**RE: FORMER YORKSHIRE TRACTION DEPOT, UPPER SHEFFIELD ROAD,  
BARNSELY**  
**OUR CLIENT: PERSIMMON HOMES WEST YORKSHIRE**

Further to your emails dated 18th August and 7th September please find enclosed the revised site layout (P09:4234:01 Rev B), which addresses the issues raised concerning the layout.

## PLOT 53 – PLANNING DRAWING

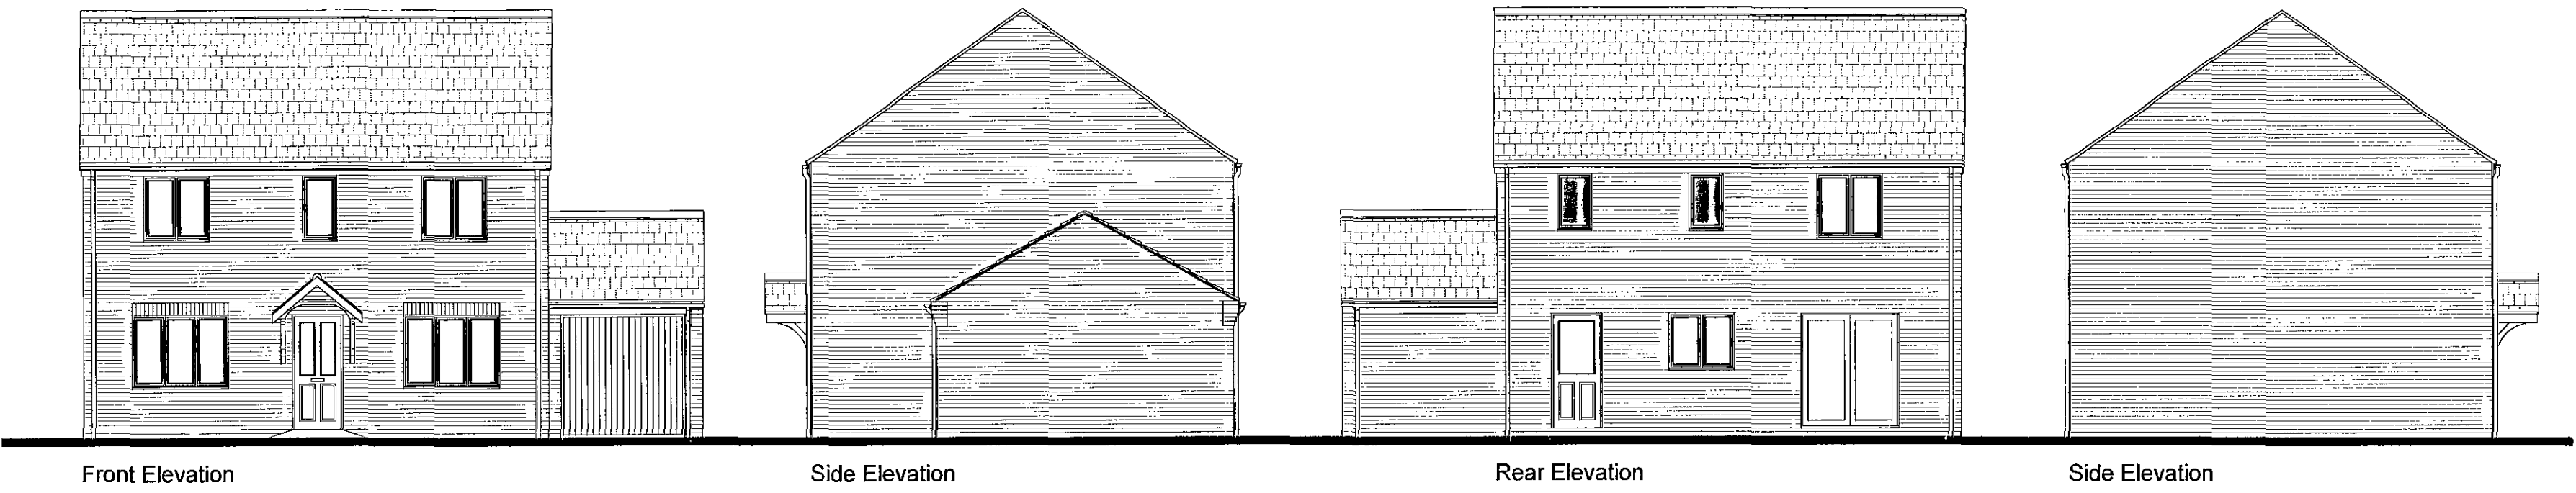
Plot 53 shows a double garage (Dwg: P09:4234:33) instead of a single garage

- Plot 52 has minimal outlook because of the proximity of plot 53, which is 2.5 storey. I suggest plot 53 becomes 2 storey with no garage.  
*Plot 53 has been amended to two storey as requested and the loss of the garage improves the amenity and garden area for plot 52.*

*We have enclosed revised plans which address these discrepancies.*

## PLOTS 111, 114, 115 &138 – PLANNING DRAWING

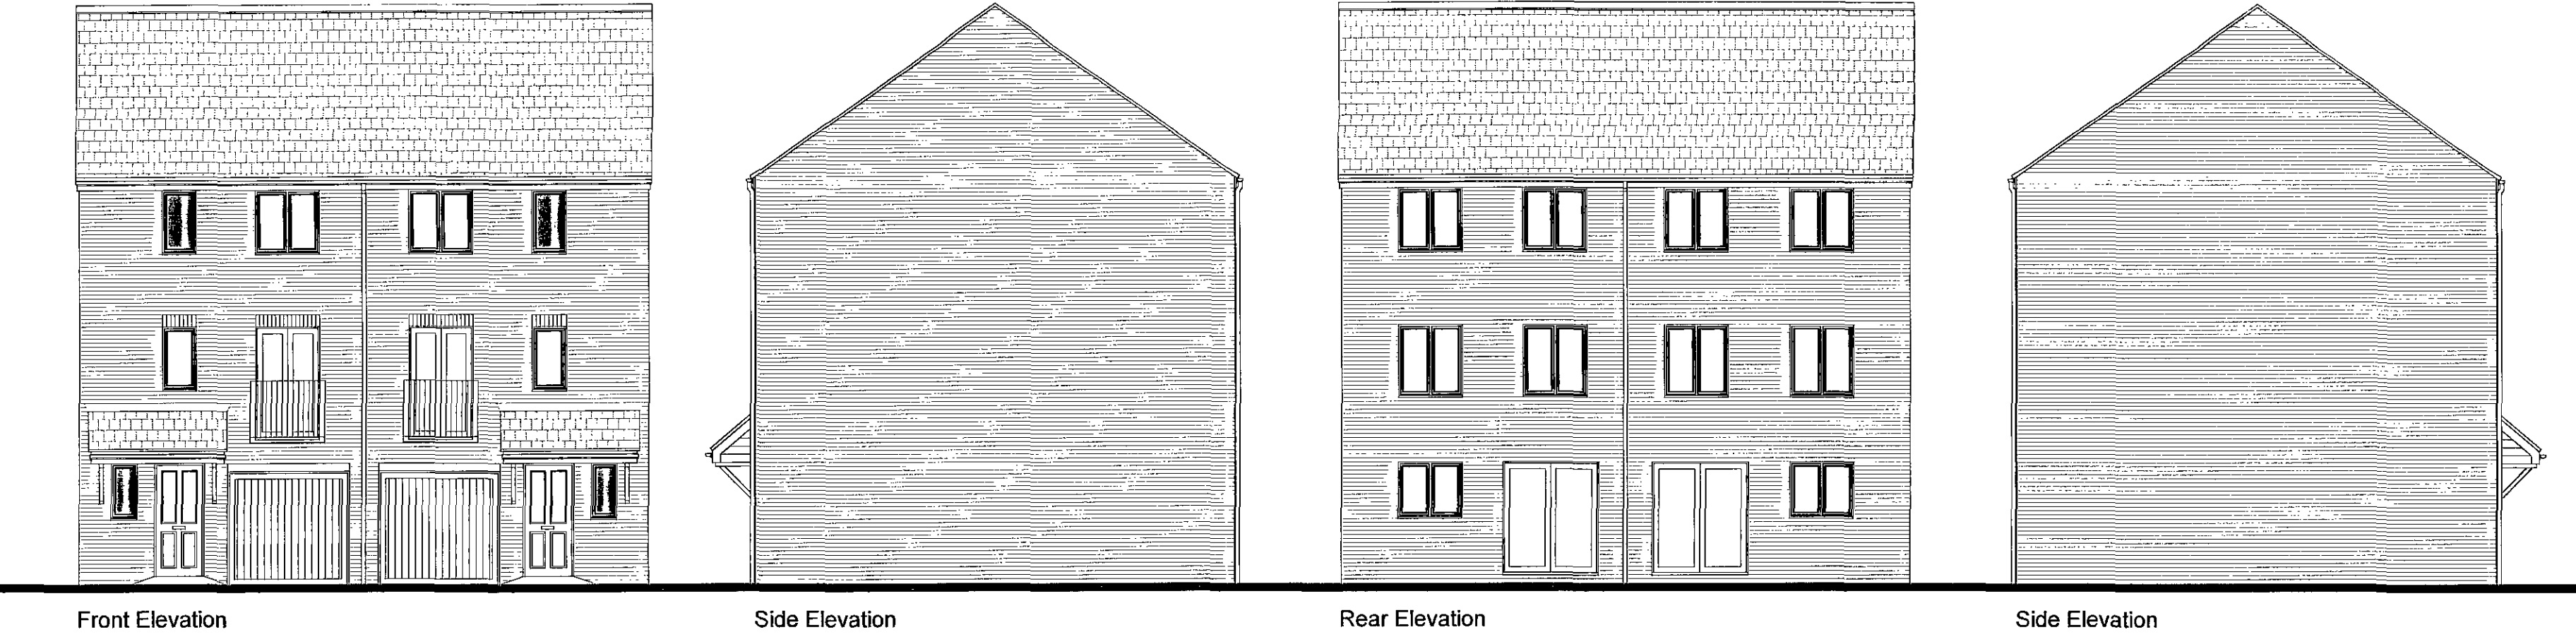
Plots 111, 114, 115 and 138 (Dwg No: P09:4234:40) – elevations do not correlate

PLOTS 189-192 – PLANNING DRAWING

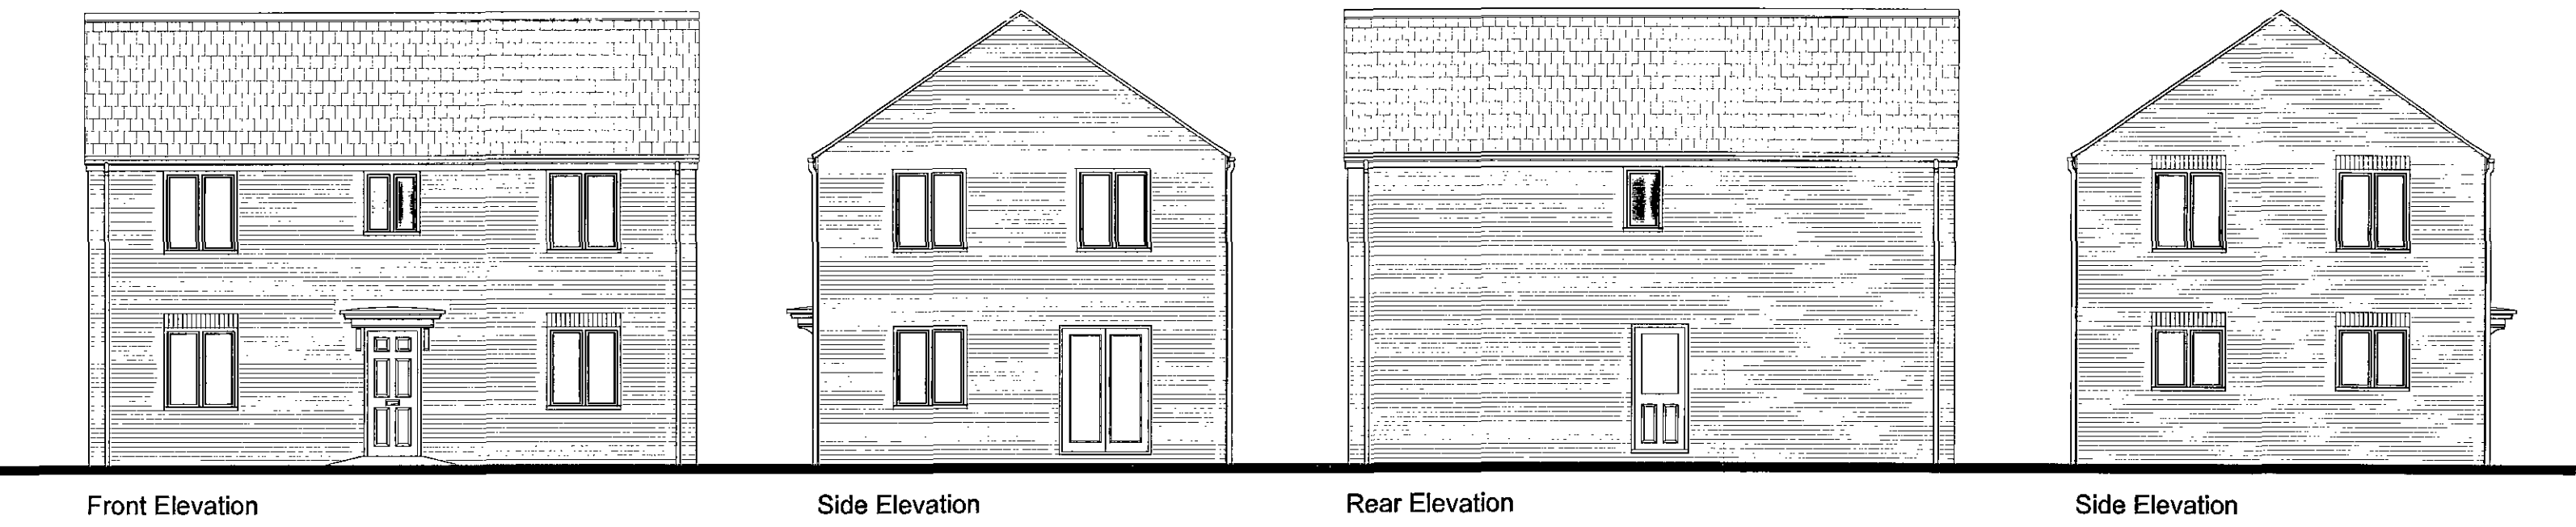
Plots 189-192 (Dwg: P09:4234:63) do not include the decking and under build, which are shown on adjacent plots

PLOTS 198-199 – PLANNING DRAWING

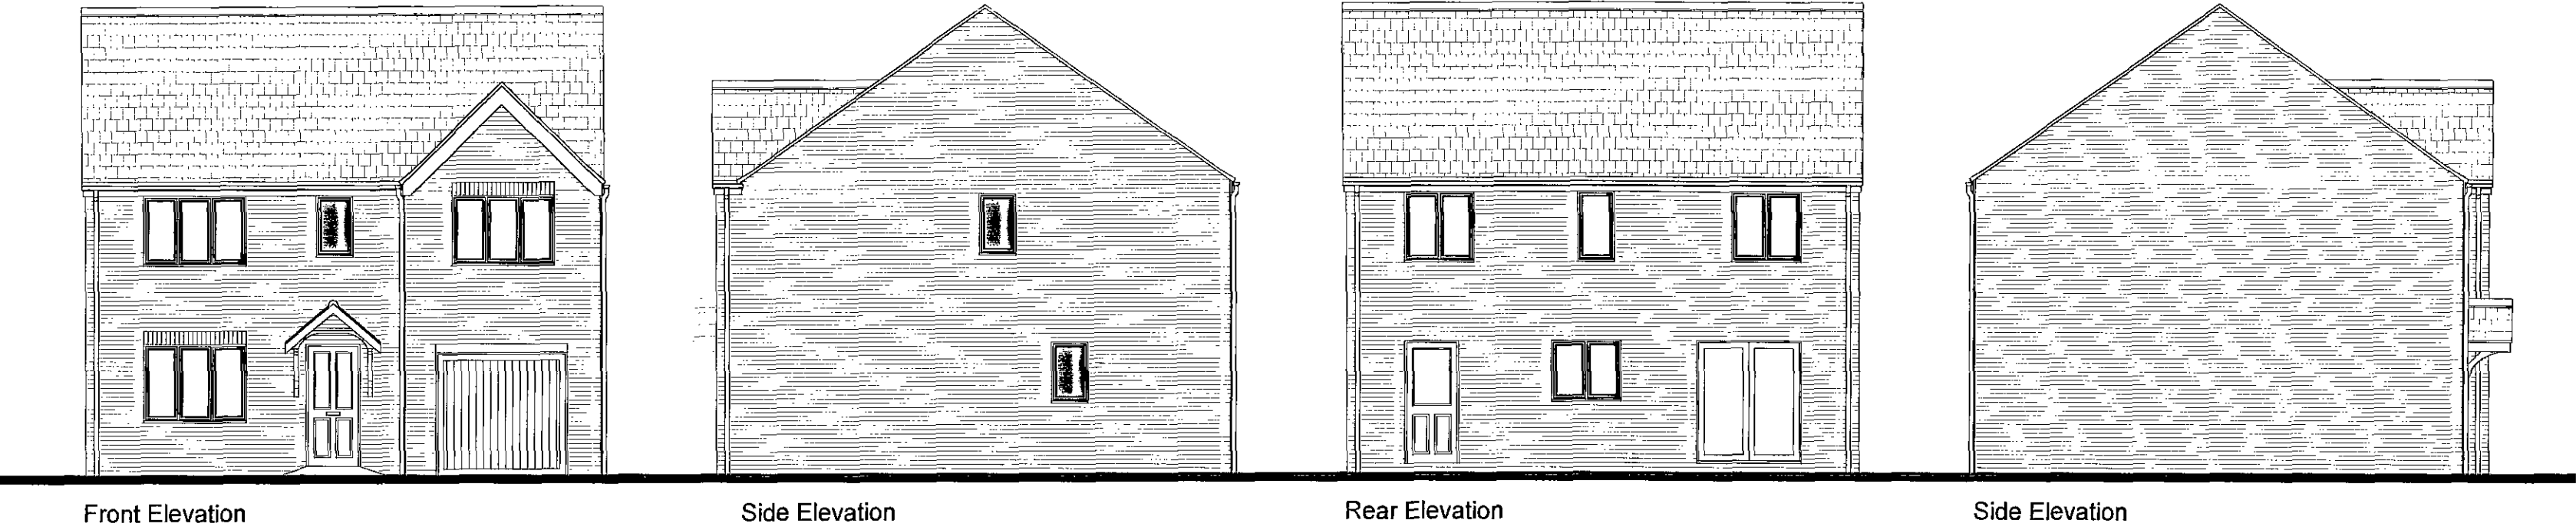
Plots 197 – 199 – The blank gable of plot 199 would be particularly prominent. It would be preferable use the same house type on plot 199 as the one proposed on plot 196 (although flipped so the windows are on the prominent side elevation). A pair of semi detached dwellings could then be provided on plots 197 and 198.

*Plot 199 (now plot 197 has been replaced with a different housetype and re-orientated and now fronts the internal road, which addresses this issue. A pair of semi-detached (plots 198-199) are now proposed in this area as suggested.*
